OXFORDSHIRE COUNTY COUNCIL'S RESPONSE TO CONSULTATION ON THE FOLLOWING DEVELOPMENT PROPOSAL

Application No: 17/01289/REM

Proposal: Reserved Matters to 15/01012/OUT - The reserved matters submission relates to Phases 2a (which comprises a section of the internal spine road) and Phase 3a (in part) which has been split into 2 plots for the purposes of delivery (referred to as plots 2 and 3). This application relates to Plot 3 and represents the first built form of the development to come forward

Location: Land North East Of Skimmingdish Lane Launton, Bicester

07 SITE PLAN
012 KEY

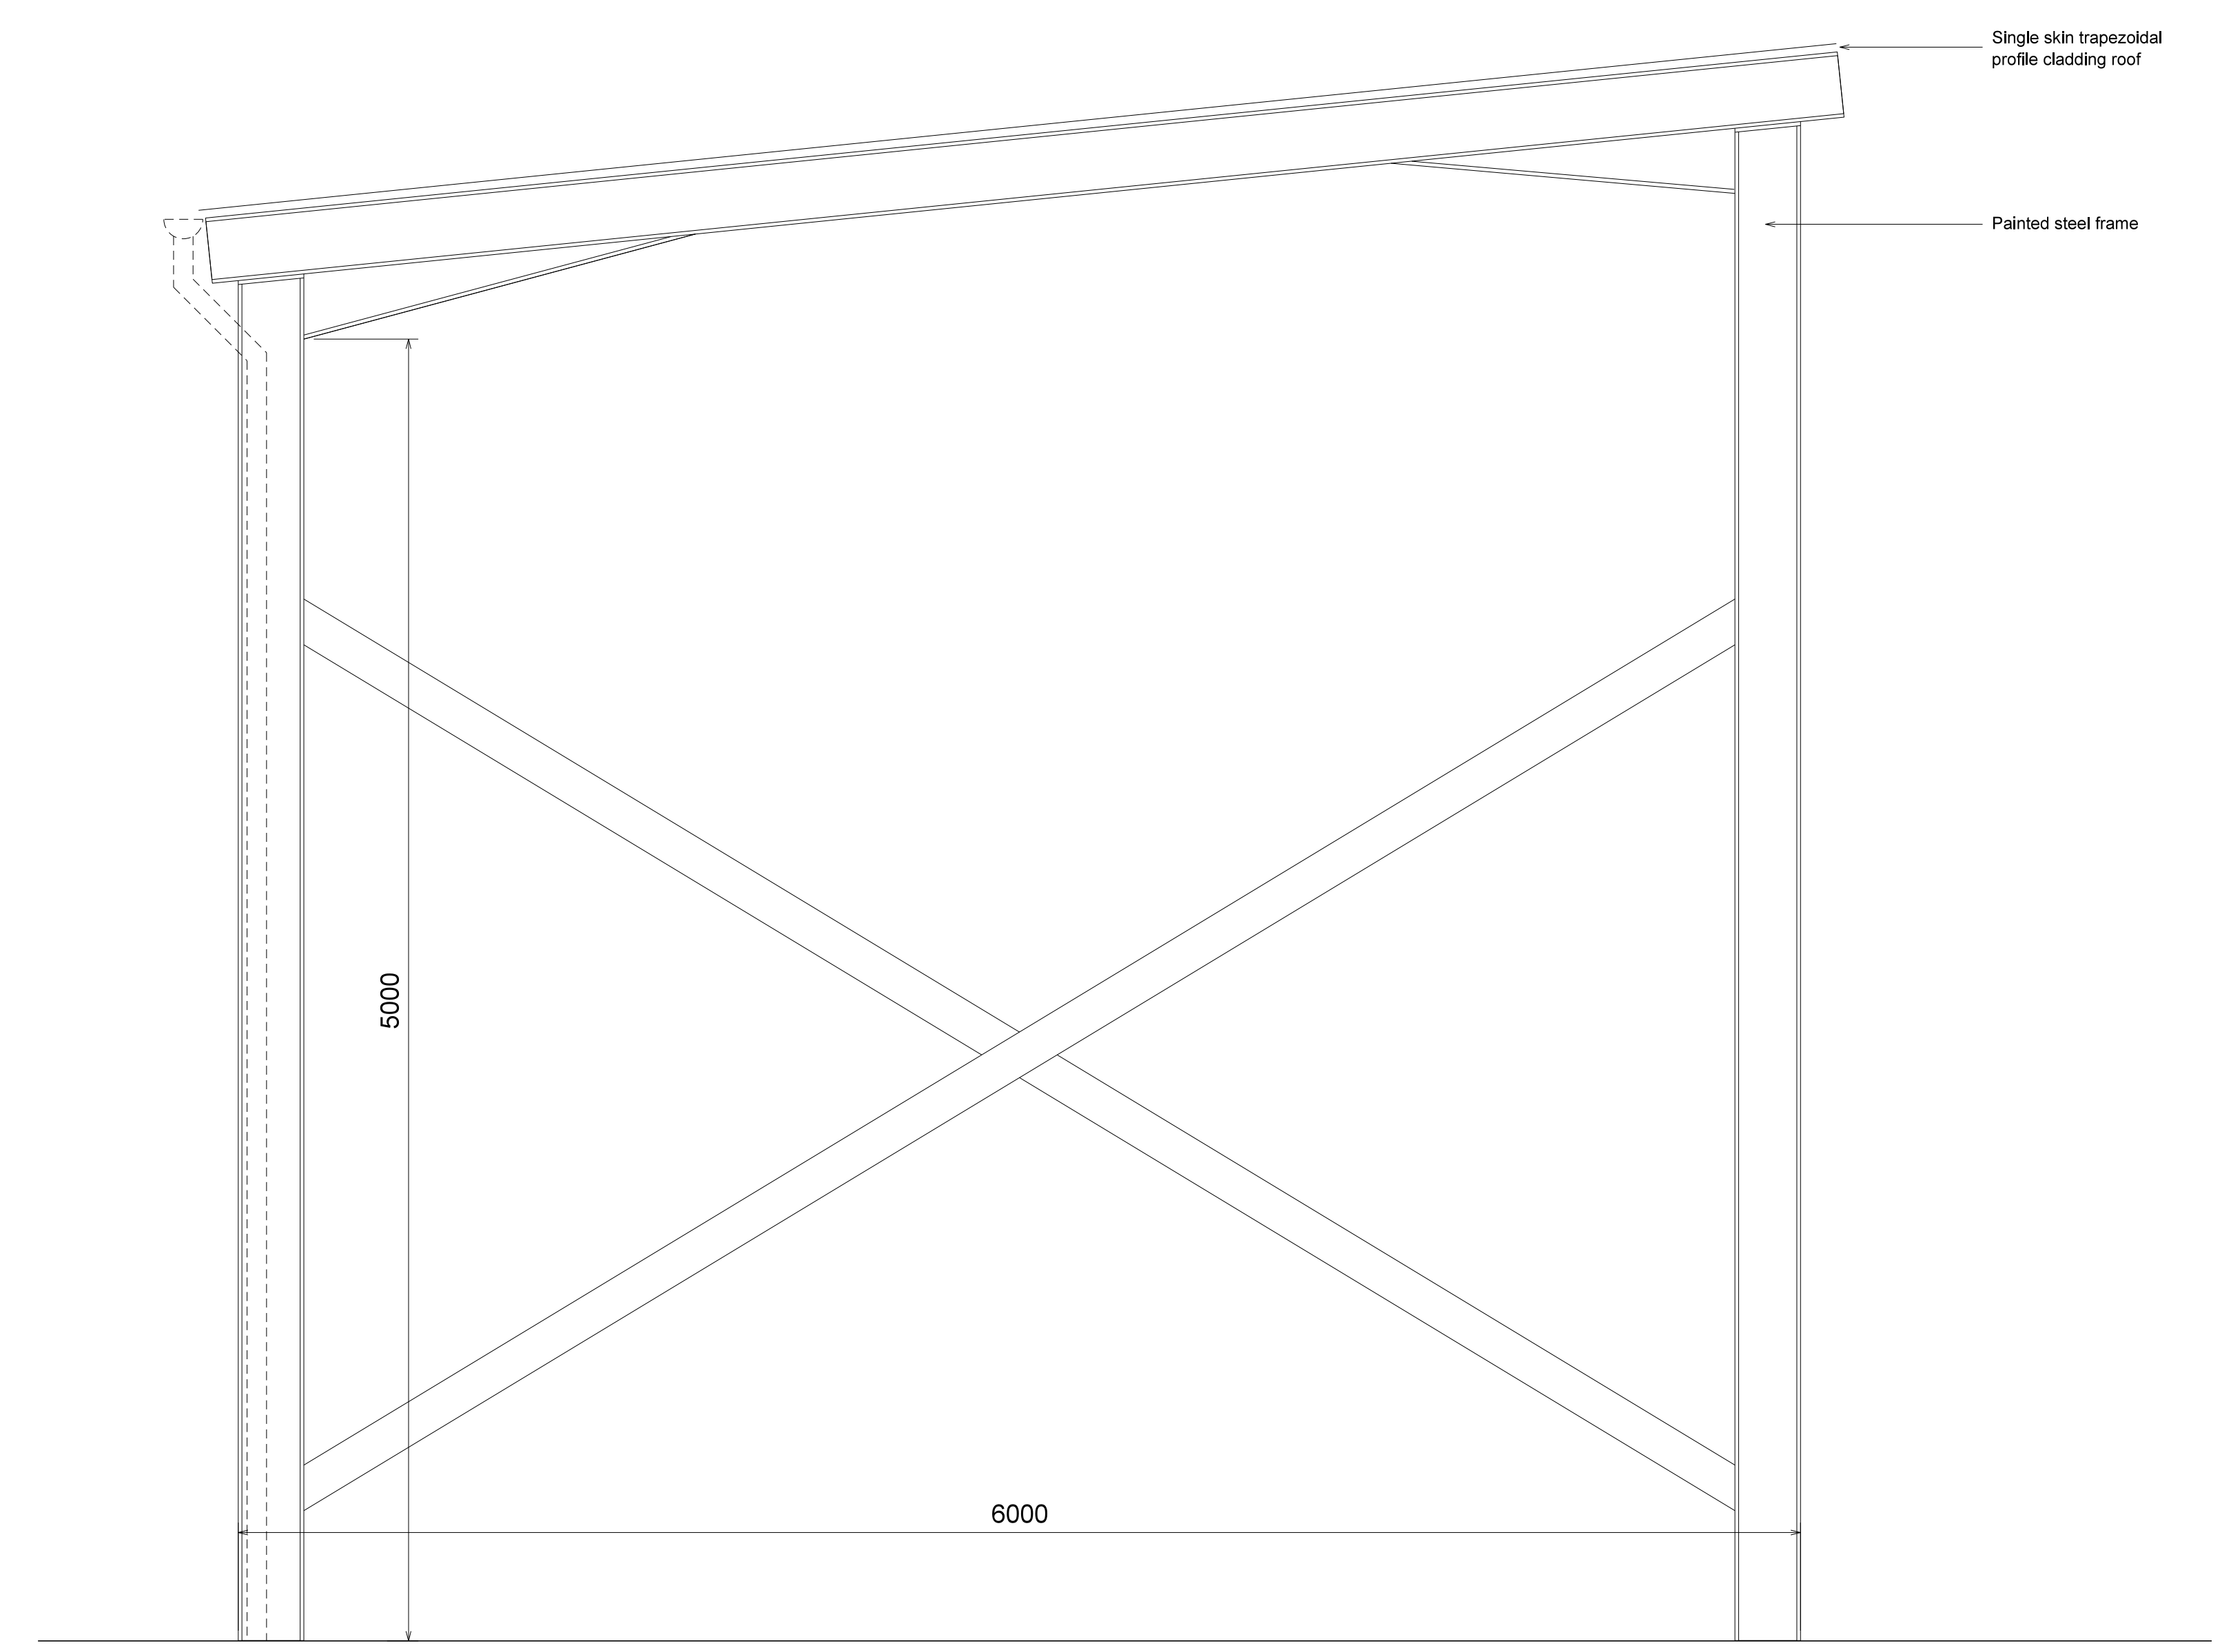
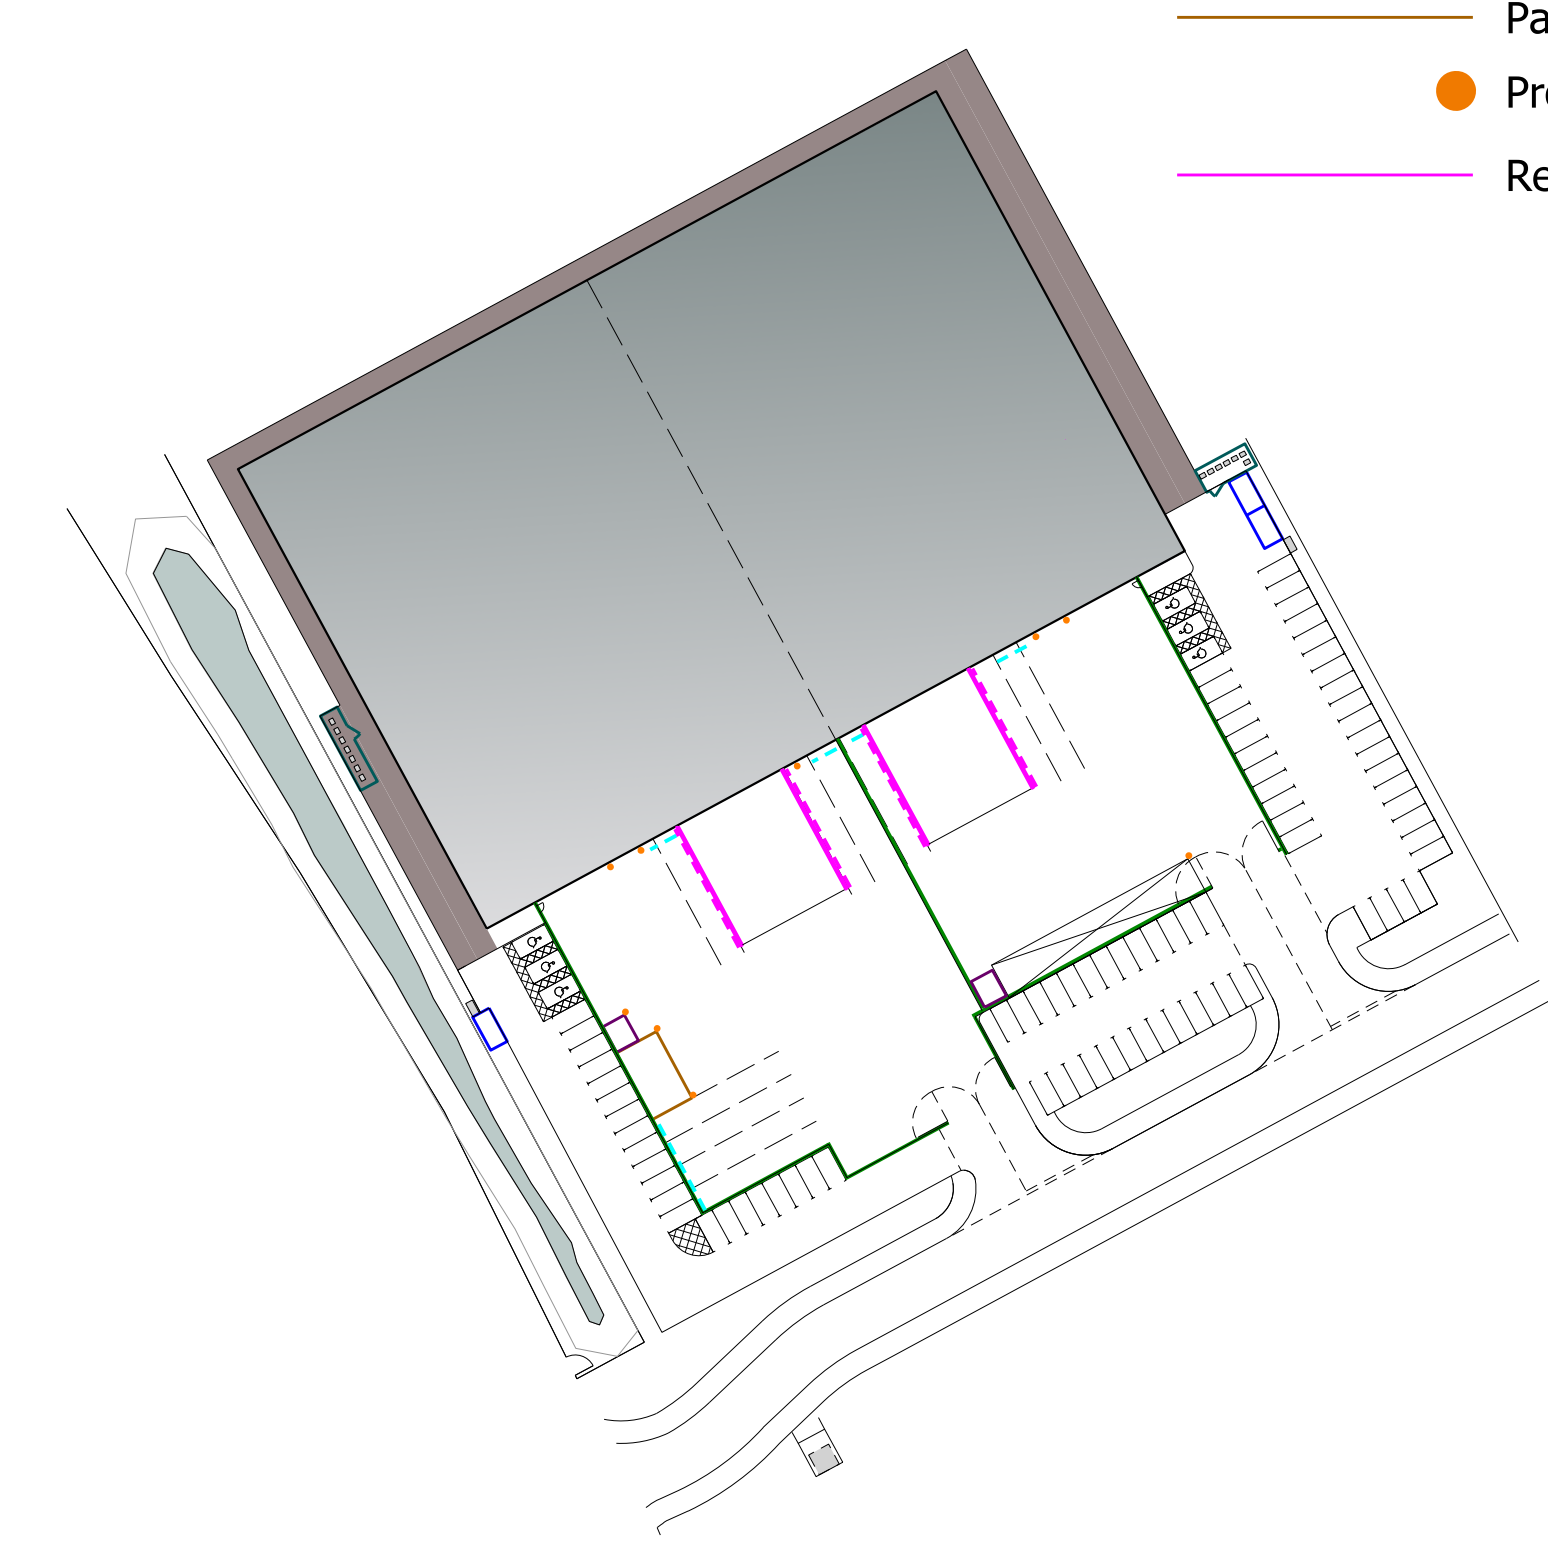
Cycle parking: A total of 18 stands (36 spaces) are required. The cycle shelter details are acceptable, but the space on the site plan does not seem adequately sized to provide this number of stands. Also there is an imbalance between the two units, which does not allow for the flexible use of the units.

Visibility at exit from unit 3B car park: visibility to the left – it is assumed that drivers will be able to see approaching HGVs through the mesh fence/gate. If this isn't the case, then the situation could be unsafe – confirmation is needed. Visibility to the site entrance and spine road must be kept clear, allowing drivers to look sideways and over their shoulder to ensure they do not exit if vehicles are turning in. The landscaping along the spine road frontage of the car park needs to be kept clear of any vegetation likely to grow to more than 0.6m high, for a distance of about 8 metres back from the car park give way line. A visibility splay line should be added to the drawing.

Cycle and pedestrian route: To encourage sustainable travel and improve user safety, a path should be provided between corner of the unit 3B car park to the spine road, which is clearly a desire line. Additionally, the footway shown on the SE side of the spine road should tie in with the 3m footway/cycleway to be provided in the S278 works – preferably it should be a 3m footway/cycleway along its length, but if cycleway is to be provided only on one side, there should be suitable crossing points. Tactiles need to be shown, including across the plot site entrances.
